Our Ref: LU/114/20/HH

**Town & Country Planning Act 1990 (as amended)
Town & Country Planning (Development Management Procedure) (England) Order 2015
Application for Planning Permission for Works or Extension to a Dwelling**

Development Rear extension larger than PD and Front Porch, including new pavement crossover.
Location 80 Clun Road Wick Littlehampton

Revision	Date	Description
Client:		
Mr & Mrs P Granham, 80 Clun Road, BN17 7EB		
Project:		
Rear Extension, Front Porch & Crossing		
Drawing Title:		
Existing Layout and Elevations.		
Scale:	Date:	Drawn By:
Noted	07/05/2020	BE
Drawing Number:		Revision:
1370/001		A

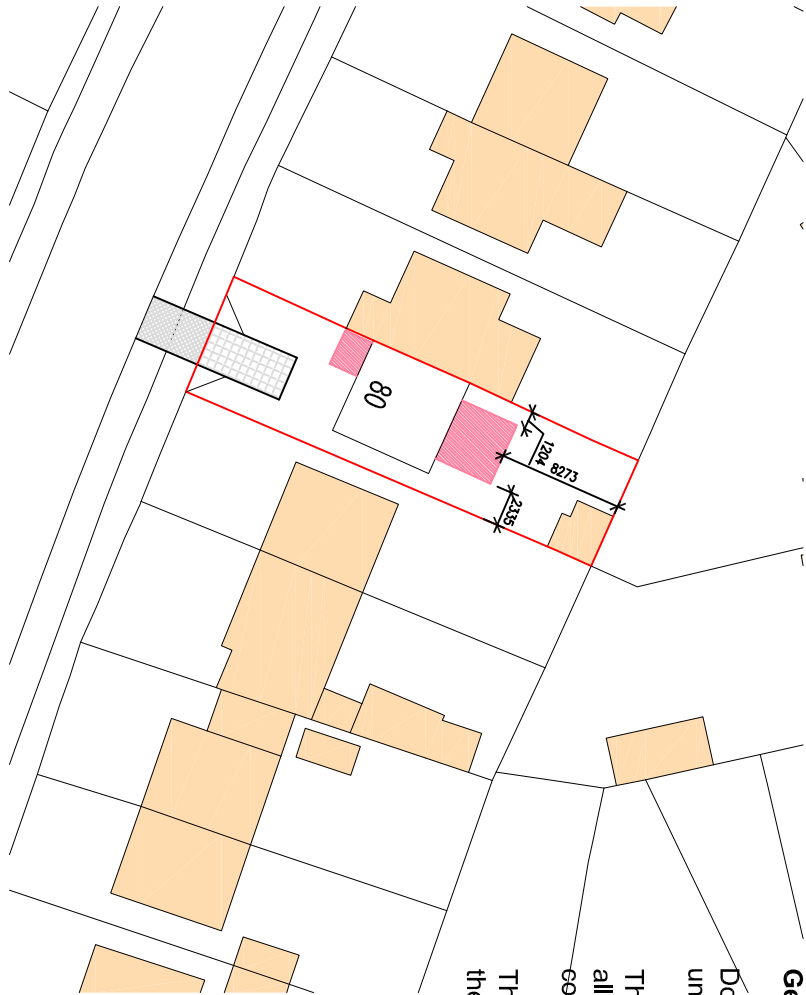
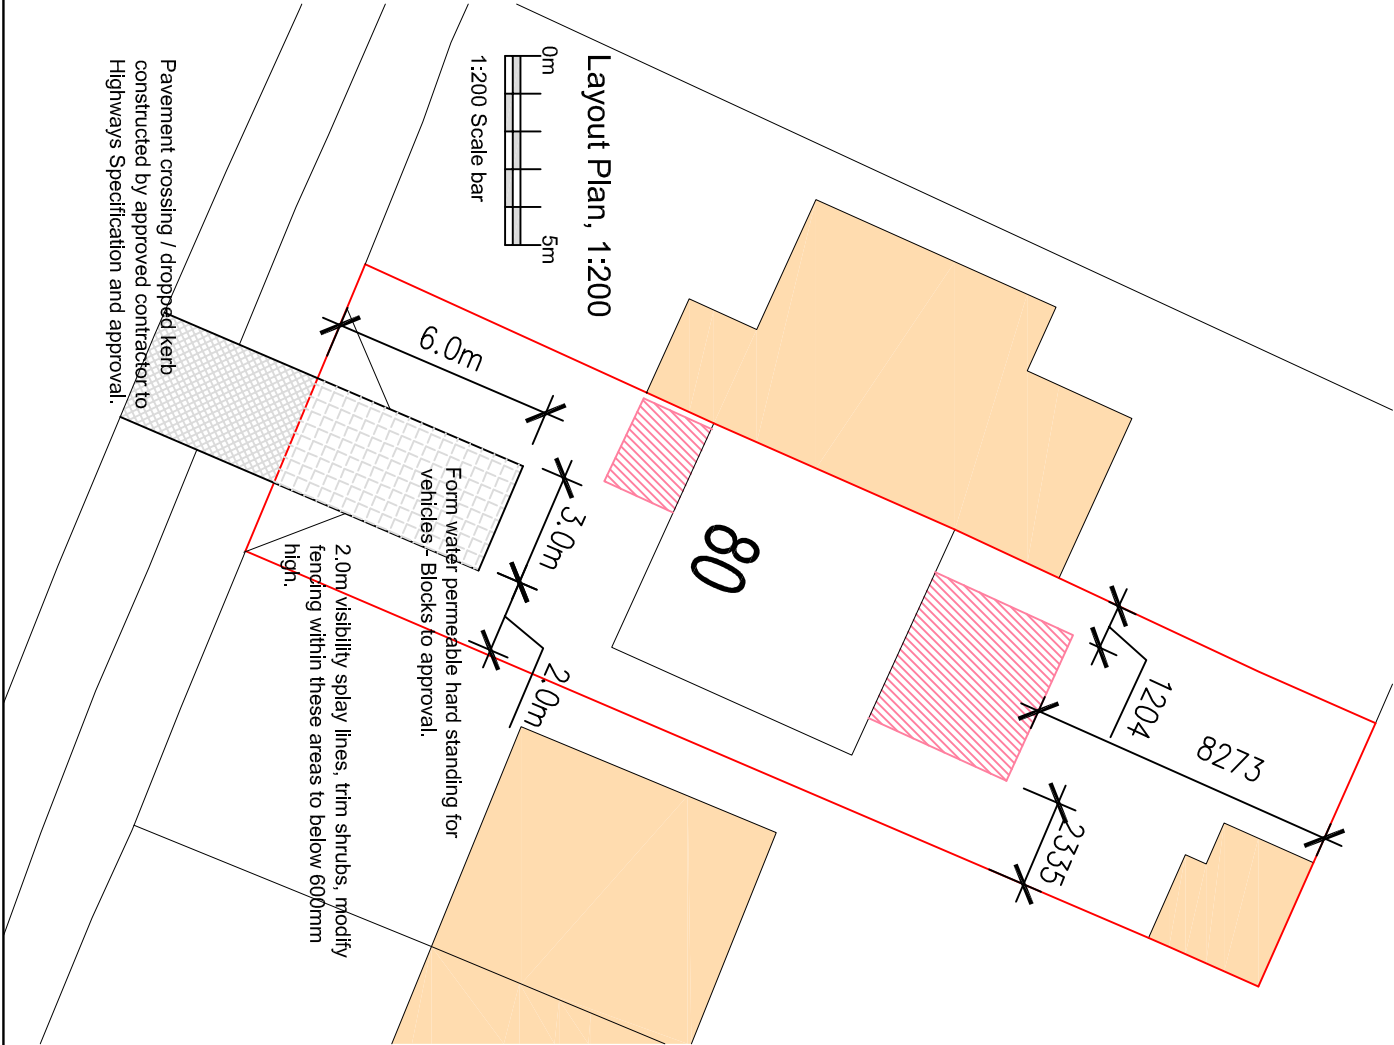
Block Plan: You are required to include dimensions from the proposed extension to all site boundaries.

Crossover: You are required to include the dimensions of the crossover.

SIDE ELEVATION - WEST
PROPOSED

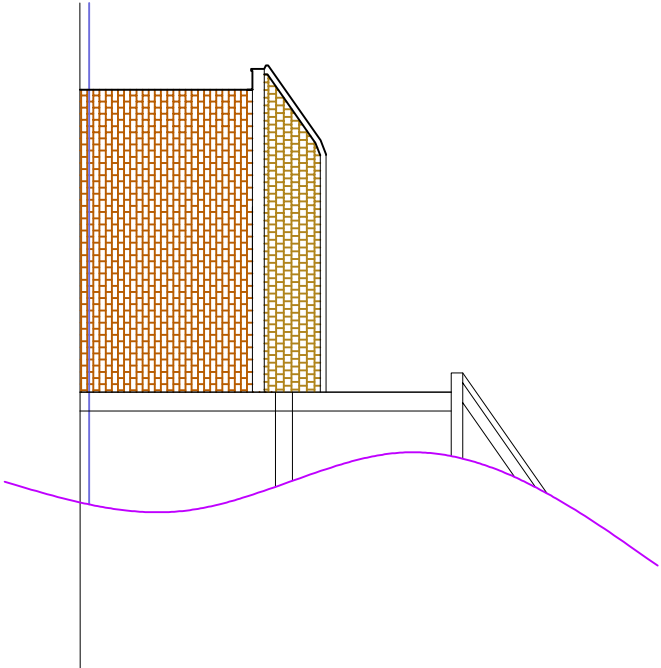
Other Side Elevation: Please provide the other side elevation for this application.
